From: [REDACTED]
Sent: 29 January 2020 15:02
To: planning
Subject: Comment on Application 3/2020/036
Attachments: 22 Brindle Close Response to 03_2020_036.cleaned.pdf

Planning Application 3/2020/036

Site Address: 28 Calfcote Lane, Longridge PR3 3SR

Proposed Block Plan

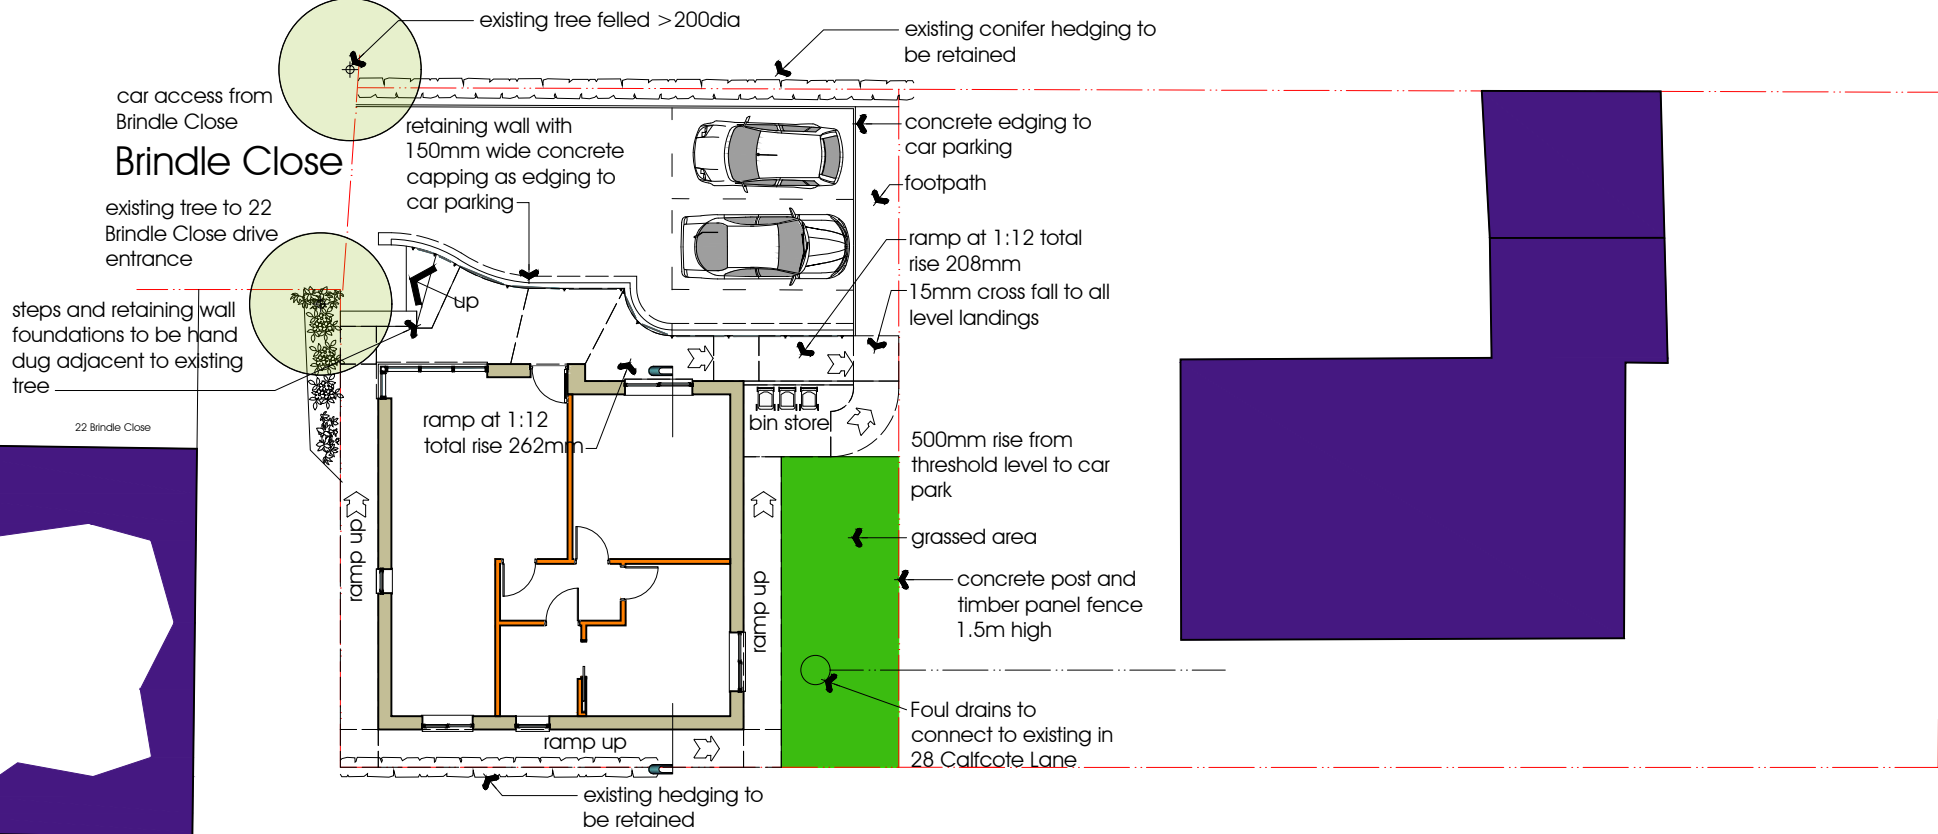
The proposed access would be immediately adjacent to the driveway of our property and the boundary that Mr and Mrs Walmsley intend to remove to allow access is a jointly owned border and they therefore do not have the right to remove it without our consent.

This change to access would significantly affect access to our drive as it will be immediately adjacent (shown in Images 4, 5 and 6). At what point will access be required? Is the intention to have access to the site via Brindle Close throughout the construction phase, or simply at the end, once construction is complete?

The area at the top of our drive is the turning circle for the cul-de-sac (Image 7) and as such plays a vital role. Our main concerns relating to this aspect of the development are:

I would very strongly like to object to this application. I am extremely concerned that the application requires an access to be made into the turning point of the cul de sac which would be detrimental from a safety point of view, particularly with regard to [redacted]'s driveway whose entrance is almost opposite the proposed access and would cause a blind spot when reversing out of this drive. There is every probability of an accident being caused by a vehicle emerging from this new access. An inspection would confirm this. I would also have a blind spot across the proposed accessway when reversing from my own driveway which is very worrying.
